TfNSW Reference: SYD15/01086/12

**SECTION 4.55(1A) MODIFICATION FOR (WESTERN SYDNEY PARKLANDS)
SYDNEY ZOO BUNGARRIBEE – SSD 7228 MOD 9**

Transport for NSW (TfNSW) is in receipt of the Department of Planning and Environment's (DPE) correspondence dated 25 July 2022, relevant to SSD 7228 MOD 9 as referred for comment.

14.5m Long Rigid Bus (Coach) Swept Path Analysis
prepared by Northrop

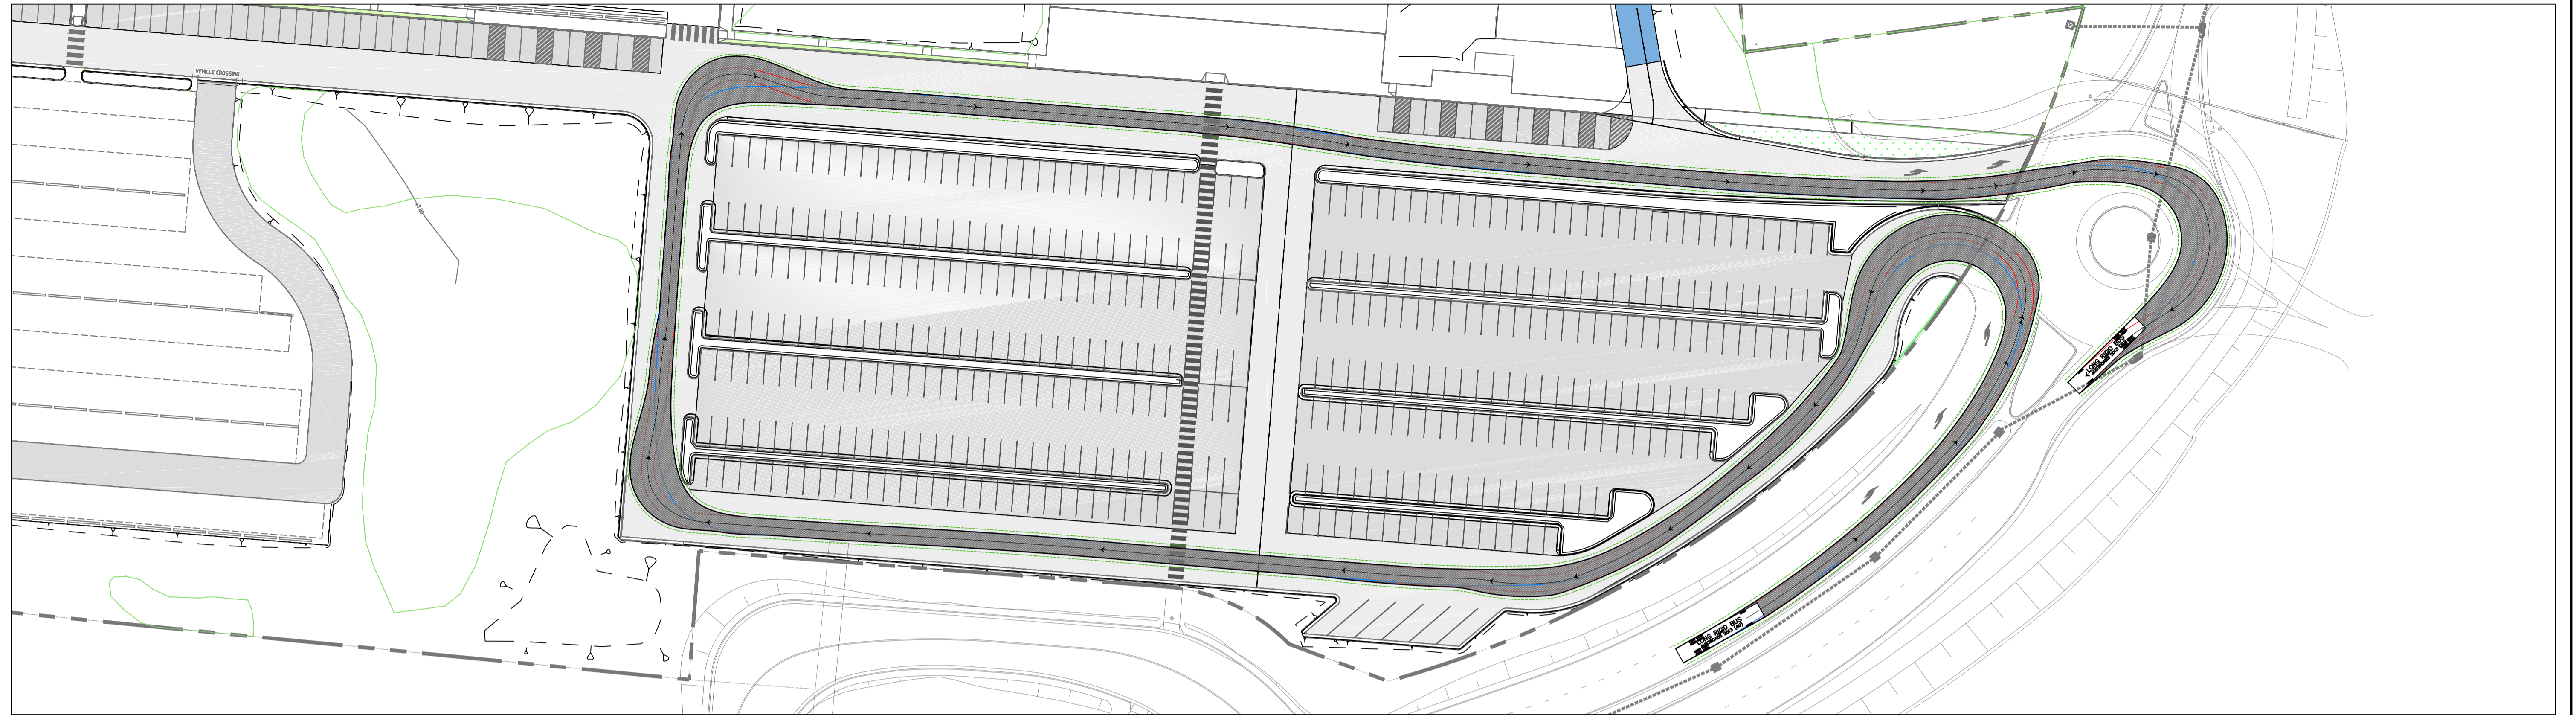
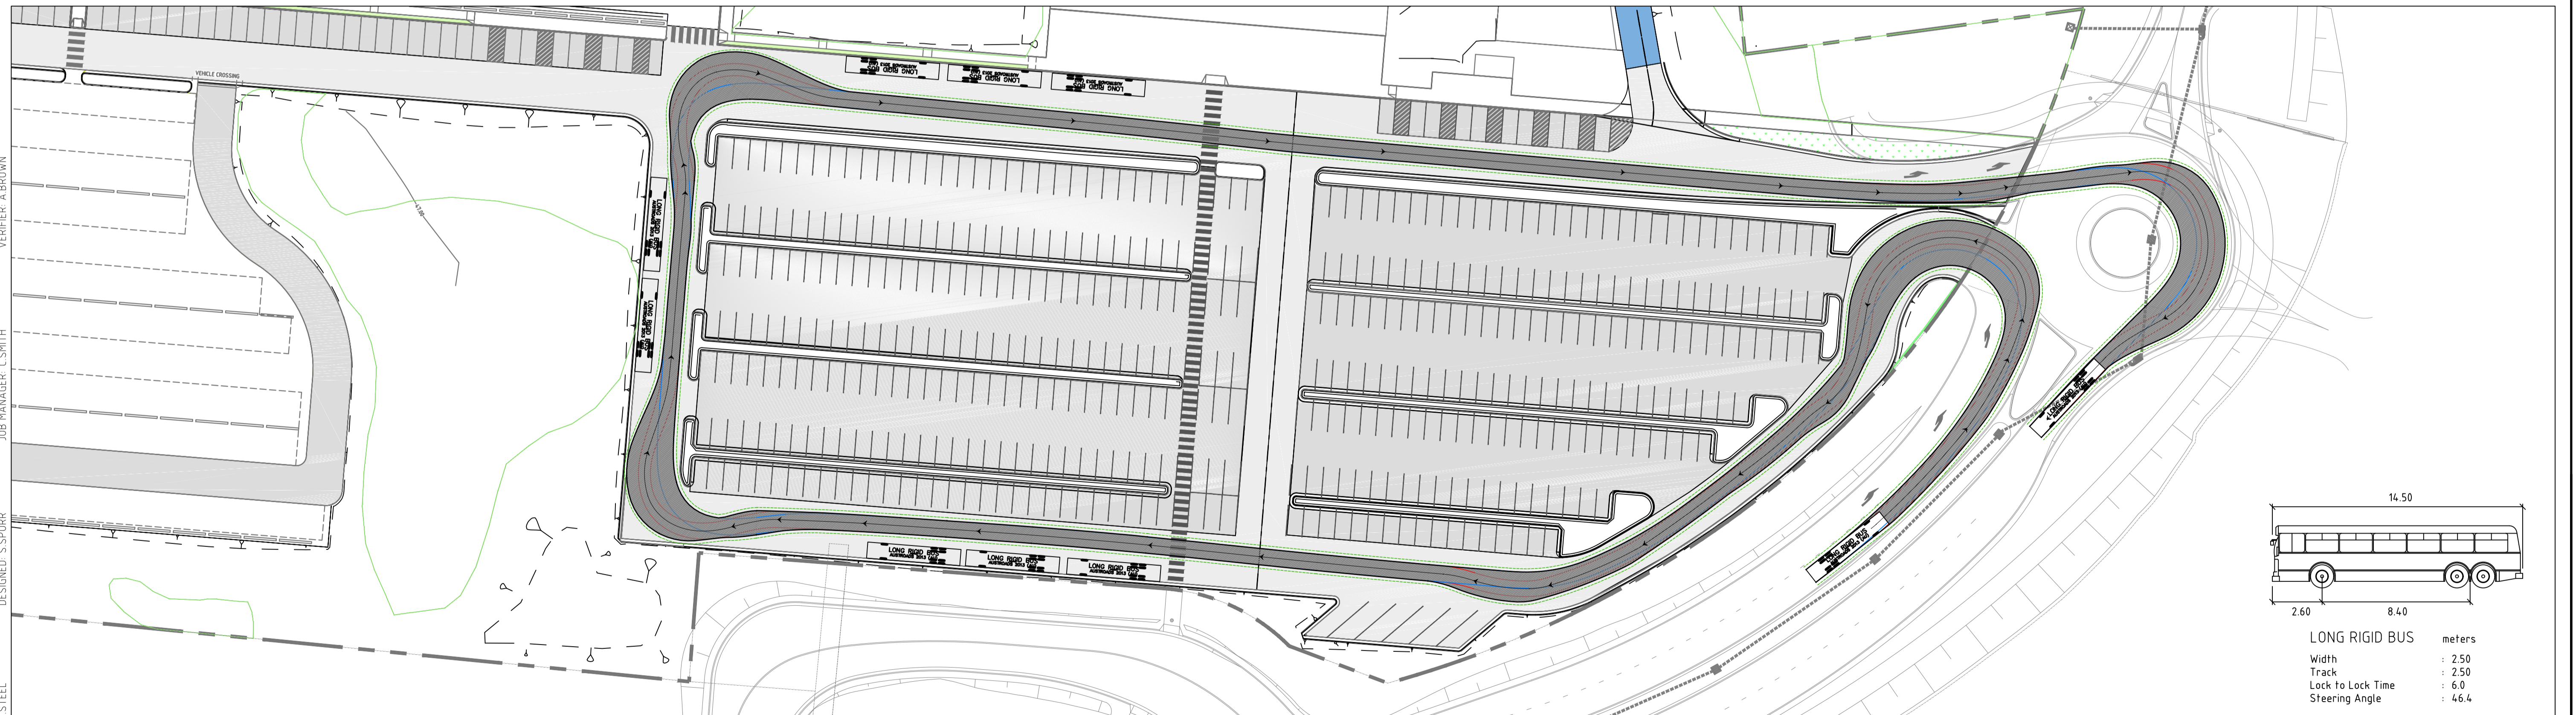
1. Further information provided by Urban Ethos confirms that the dwell time for coaches is 1 hour however lacks adequate information or justification to support the statement.
2. TfNSW reiterates adequate space for coach parking should be provided onsite whilst ensuring there is no conflict between coach and staff parking and manoeuvring areas or potential for queuing.
